Rezoning Transportation Analysis

Petition Number: #2021-120

Date	Description
09-28-2022	First Review (AO)
10-27-22	Second Review (TM)
11-28-22	Third Review (TM)
02-22-23	Fourth Review (IW)

Revised Site Plan 11.14.22

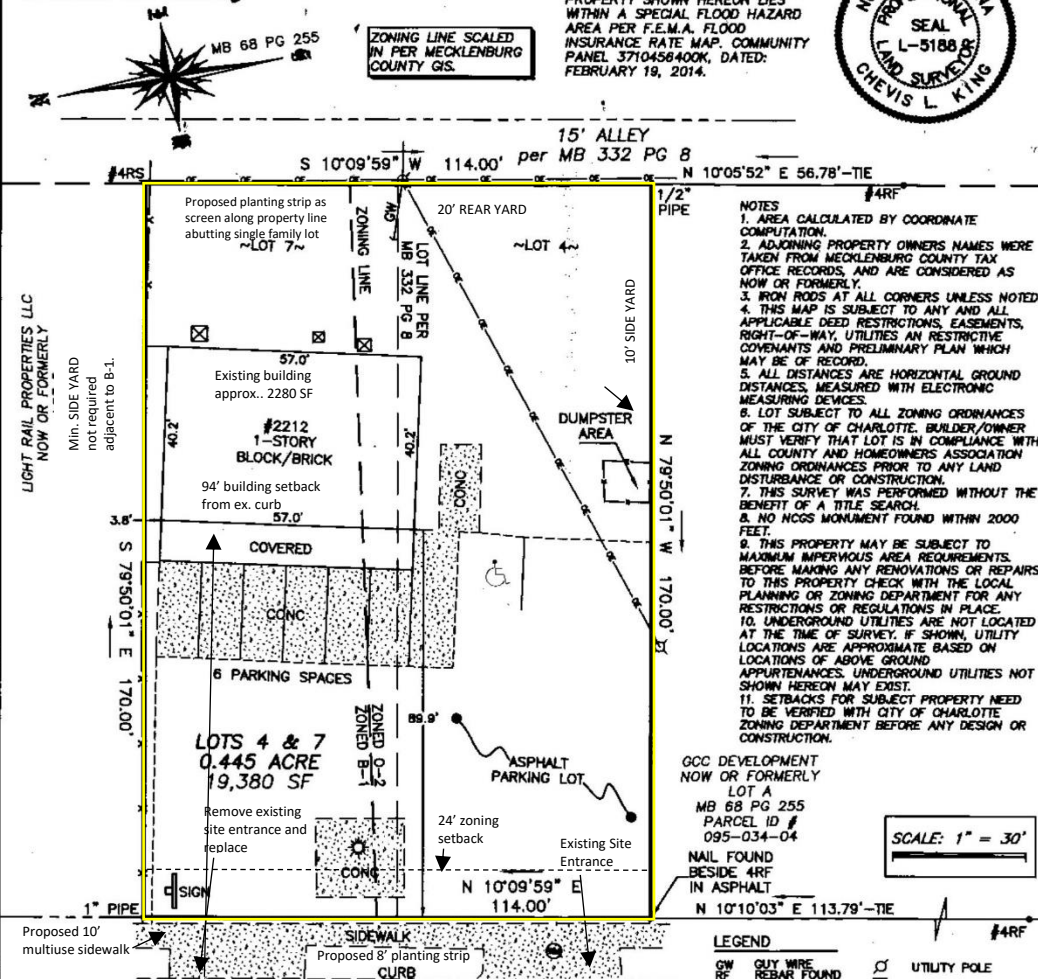
3. Revise site plan and conditional note(s) to commit to dedicate minimum 50 feet of right-of-way from the road centerline of The Plaza if it does not currently exist. The site plan shall label and dimension the right-of-way from the road centerline.

Outstanding Comment 10-27-22: Dimension right-of-way from the centerline of the roadway. Add conditional note committing to dedicating 50-feet of right-of-way if it does not currently exist.

5. **Outstanding Comment from 9-28-22:** Revise site plan and conditional note(s) to commit to removing existing bike ramp and green pavement markings just north of site. The site plan shall label and dimension both items from the back of curb and gutter.

Outstanding Comment 10-26-22: Revise site plan and conditional note(s) to commit to restriping existing green pavement marking to a dedicated right turn lane and removing existing bike ramp just north of the site. The site plan shall label and dimension both items from the back of curb and gutter.

Outstanding Comment 10-26-22: After further coordination the above design has been updated as follows to. Revise site plan and conditional note(s) to commit to remarking current bike lane pavement markings to a dedicated right turn lane, a bike ramp near south property line per CLDSM 10.43 to transition bicyclists from separated bike lanes to multi-use path and extending the 10-foot multi-use path to the southern property.

8. **New Comment from 11-28-22:** Revise conditional note saying "Removal of second driveway if needed according to CDOT ordinance for NS Zoning" to say "Close northern driveway". Revise callout saying "Remove existing site entrance and replace" to say "Close northern driveway".

9. **Outstanding Comment from 9-28-22:** A site plan note(s) specifying dedication and fee simple conveyance of all rights-of-way to the City before the site's first building certificate of occupancy is issued is needed. CDOT requests rights-of-way set at 2' behind back of sidewalk where feasible.

10. **Outstanding Comment from 9-28-22:** A site plan note specifying that all transportation improvements will be approved and constructed before the site's first building certificate of occupancy is issued is needed. The petitioner may phase transportation improvements if said improvements and phasing are explicitly described in site plan notes.
